Rezoning Petition Review – Charlotte Tree Ordinance

Subject: City of Charlotte – Urban Forestry Rezoning Petition Review Summary

Review Date: August 26, 2021

Rezoning Petition: 2021-090

SHEET NUMBER
RZ101

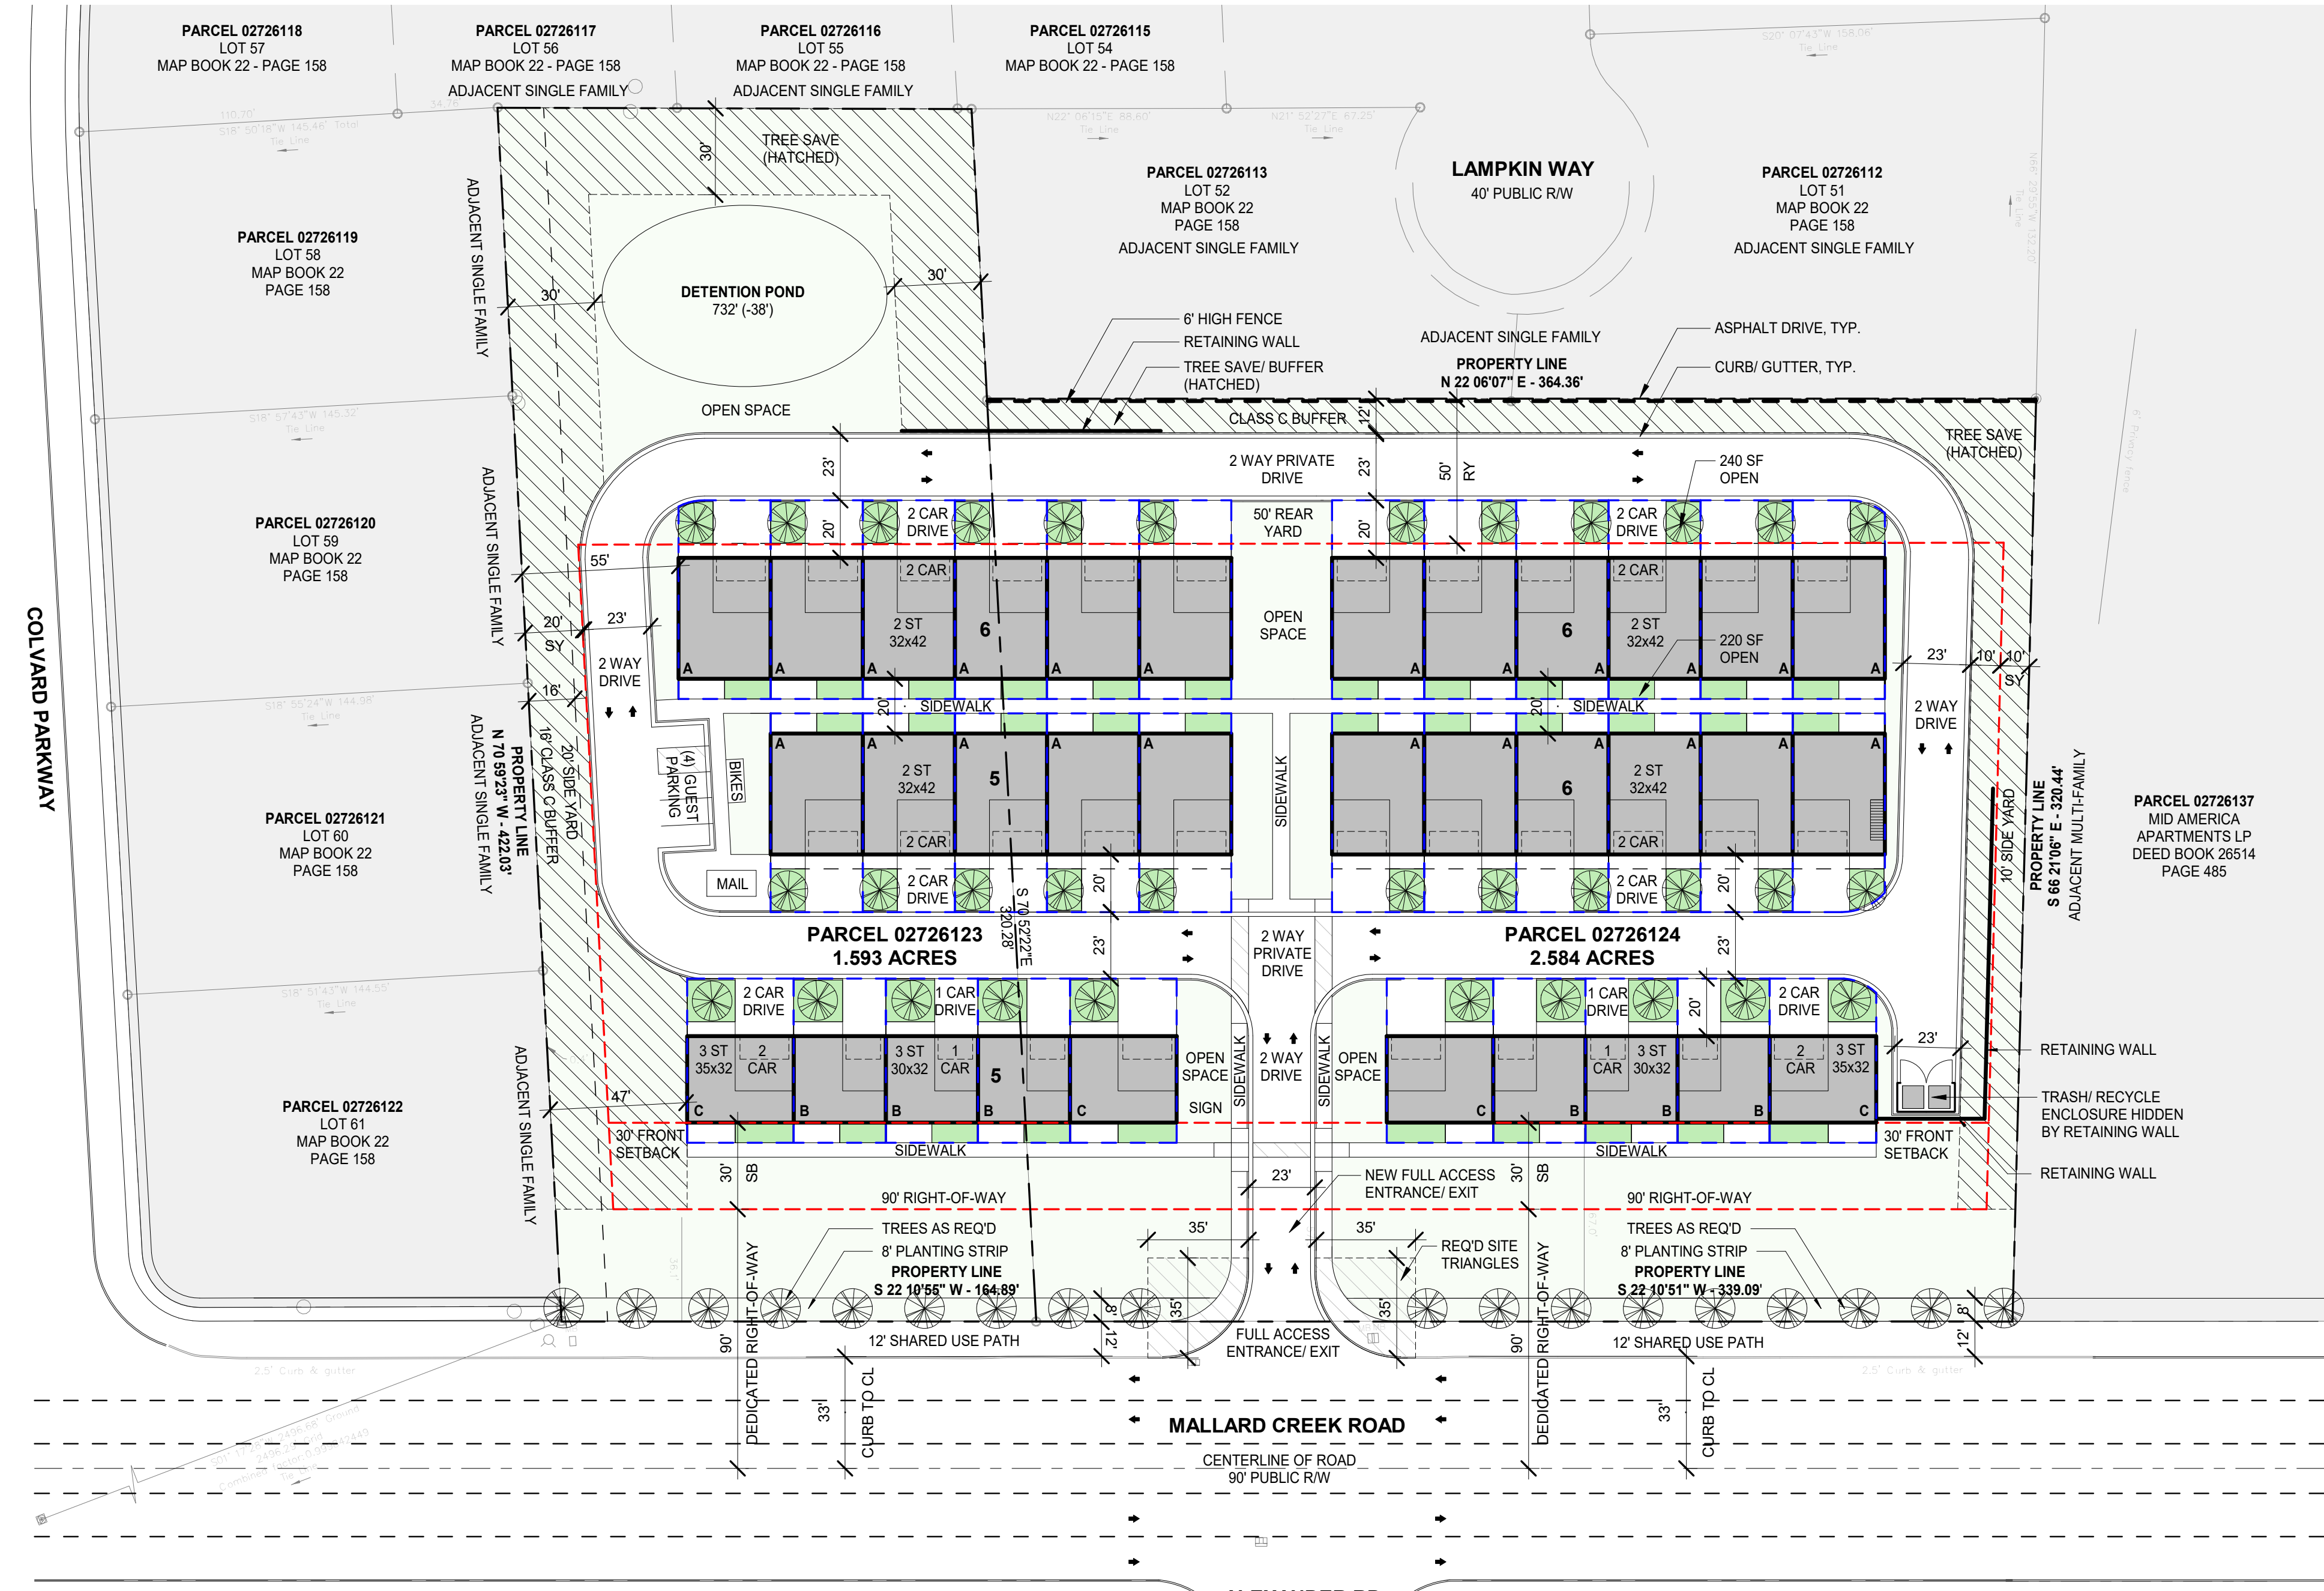
- A tree survey shall be submitted identifying all trees of eight-inch (8) dbh or greater and all planted trees of (2) two-inch caliper or greater and six feet in height that grow partially or wholly within public street right-of-way.

- All existing City street trees in public street right-of-way (City or State-maintained) are required to be preserved per the Charlotte Tree Ordinance and the following Tree Ordinance Guidelines:
 1. City Trees & Protected Vegetation
 2. City Tree Mitigation Policy

- Conditional rezoning petition submittals shall provide notation referencing how tree save requirements will be met by the site and depict potential tree save areas.

- Perimeter trees are required to be planted along all public roads per the Charlotte Tree Ordinance.
 - o Small-mature tree species are required in locations where overhead distribution lines may impact natural tree growth.
- Internal Trees: Internal trees may be required to be planted in all surface parking lots and to mitigate impacts from impervious surfaces on-site.
